Landscape Briefing Note 5

Project: 1080 East Anglia One North and East Anglia Two
Date: 10th January 2021
Purpose: Notes responding to SPR's Deadline 3 submissions
Reference: 1080 BN05 Deadline 3 Responses Final R1.docx

**Figure: 29.21c**  
 Viewpoint 9: B1121 Aldeburgh Road, south of Friston

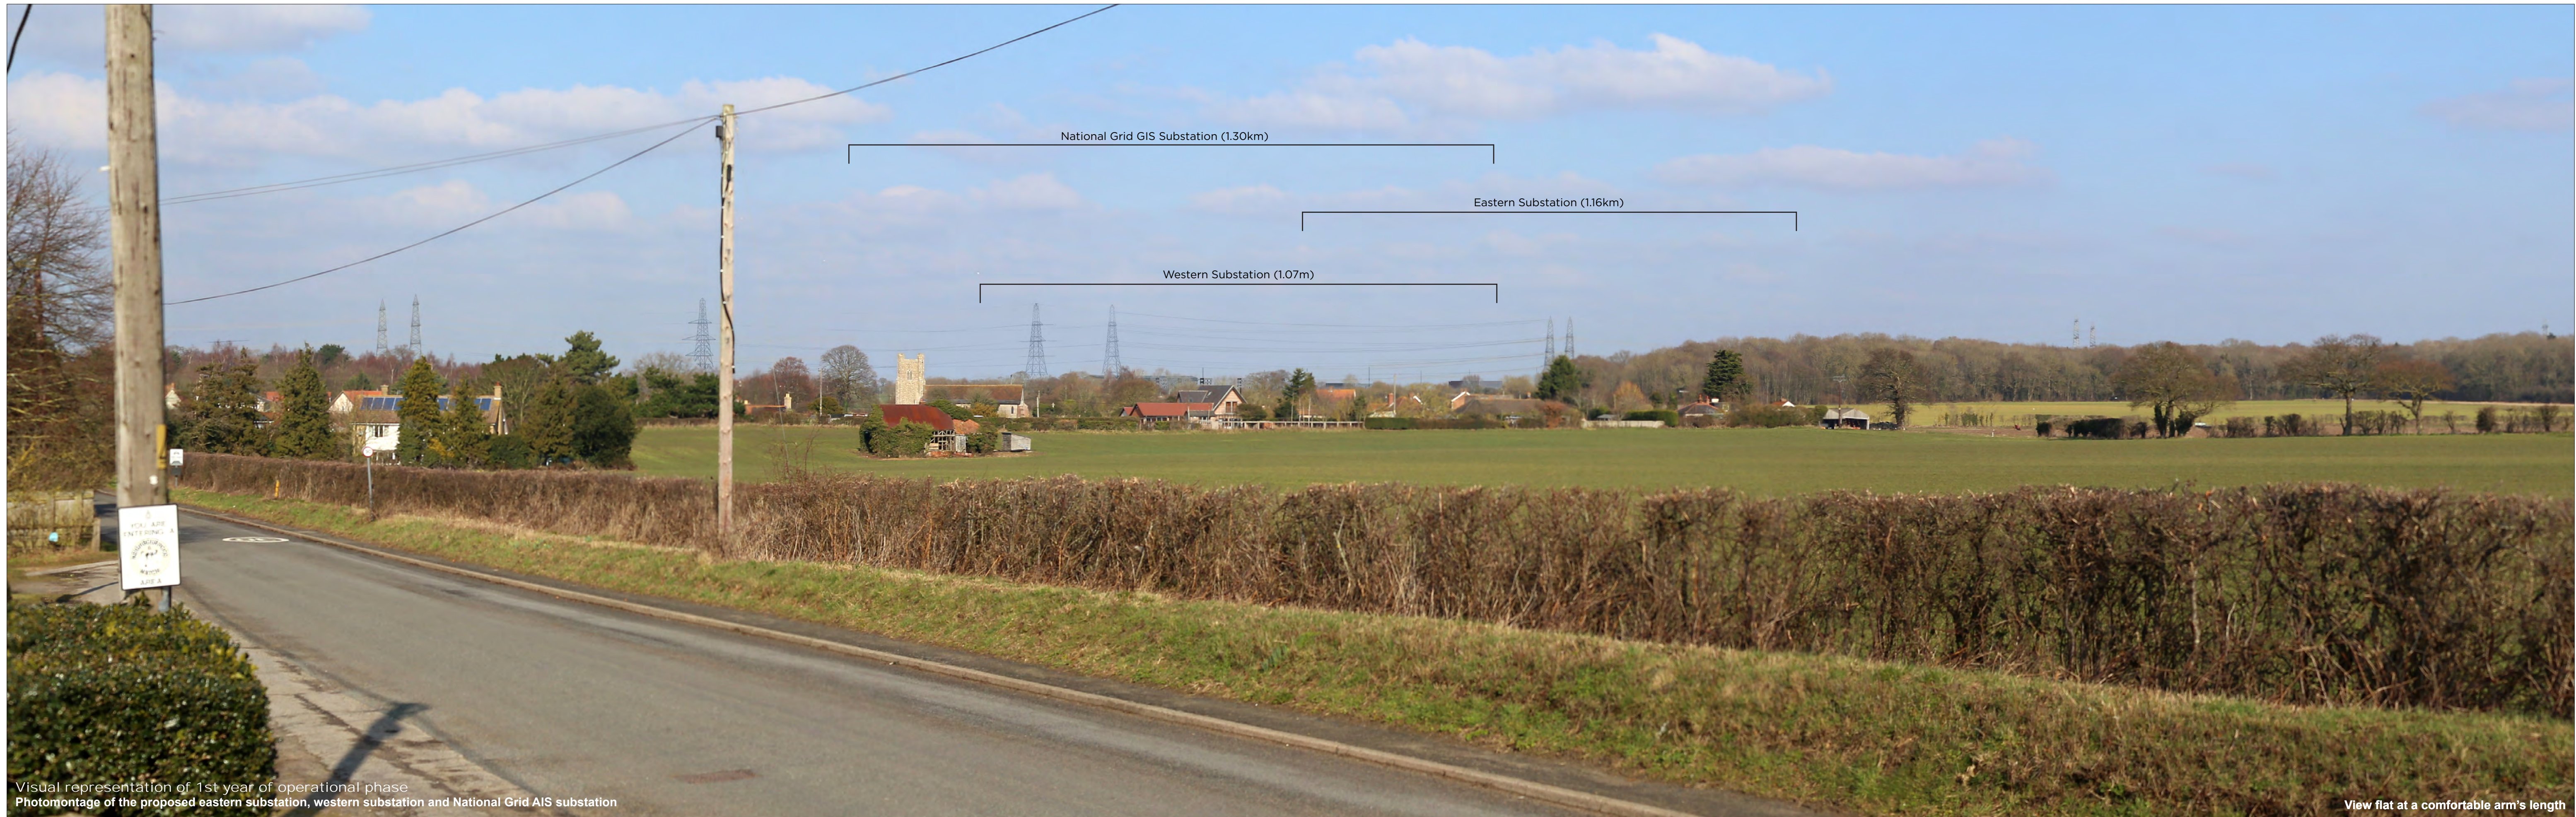
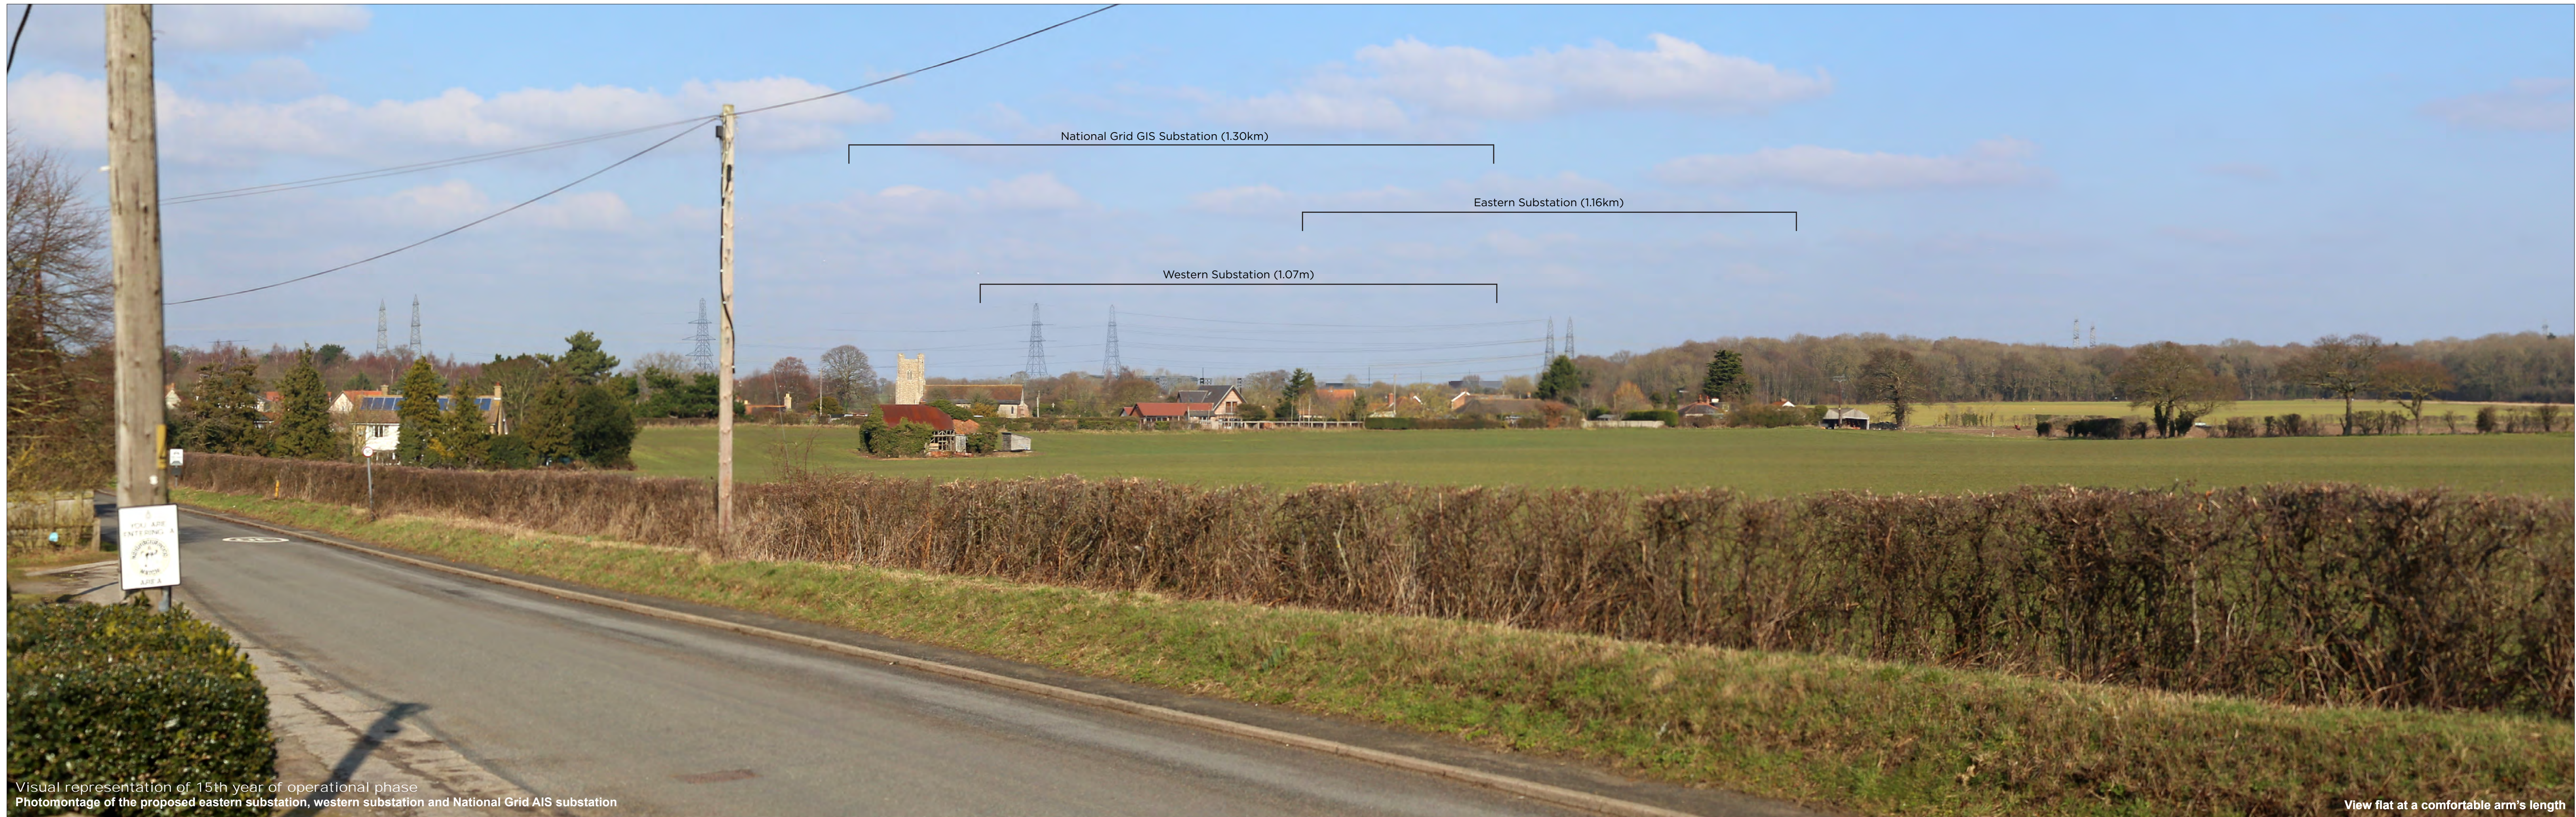
10. It is not clear that the difference evident in the revised photomontage from Vp 9 is a result of the reduction in ground level or the reduced building heights, although the reduction in height of the Harmonic Filters is beneficial. However, the most noticeable change here also appears to be as a result of the new arrangement, in particular the relocated Super Grid Transformers and associated equipment. As set out above the precise layout of the substations is not currently controlled by the DCO and so any resulting improvement cannot be relied on.
